**SOIL/SITE EVALUATION
 for ON-SITE WASTEWATER SYSTEM**

Owner: *MRH Land Holding* Applicant:
 Address: *186 Wildwood Way*
 Proposed Facility: *SFR*
 Location of Site: *same*

Date Evaluated: *11-4-2020*
 Design Flow (.1949): *360 GPD*
 Property Recorded:

# Harnett County Department of Public Health Site Sketch

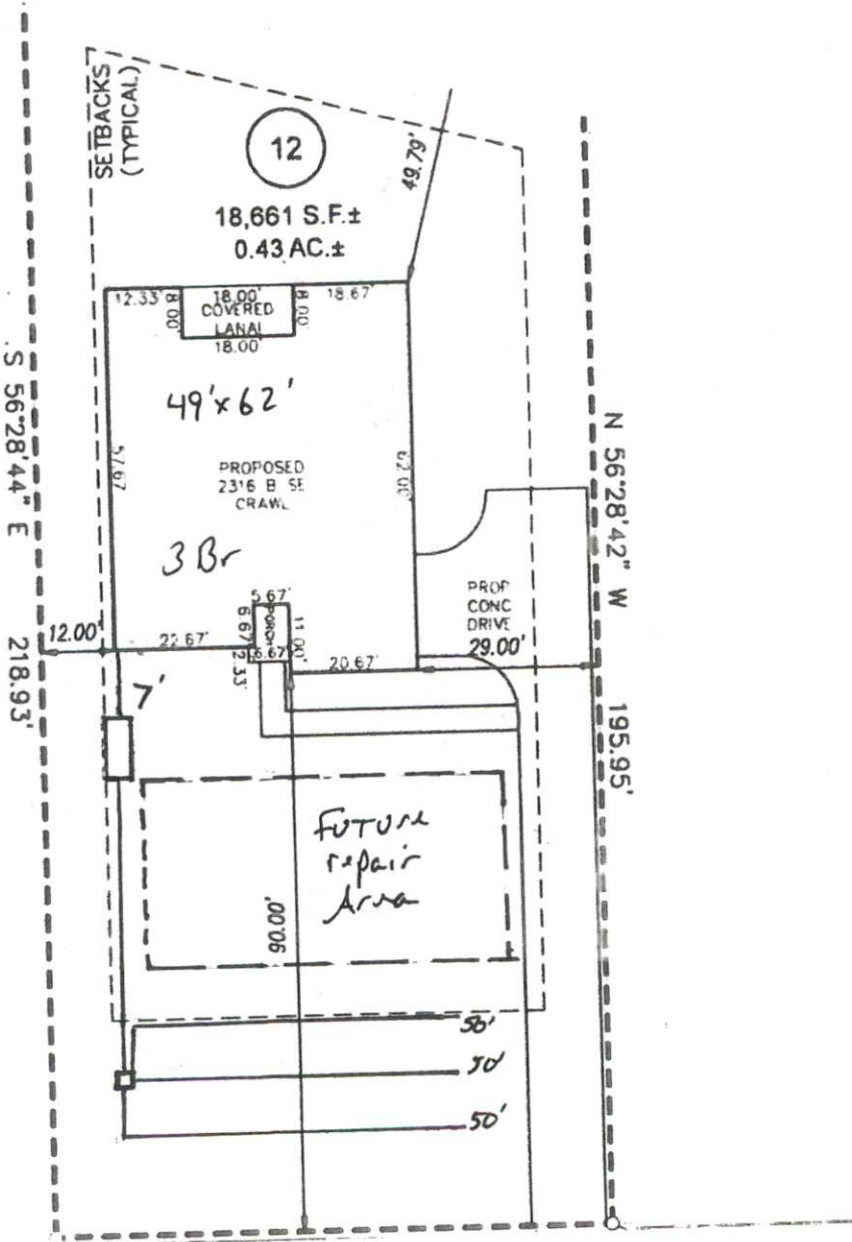
** recommend moving house
 back by 40' to gain
 access to suitable soils
 for Drain Field + R.A.*
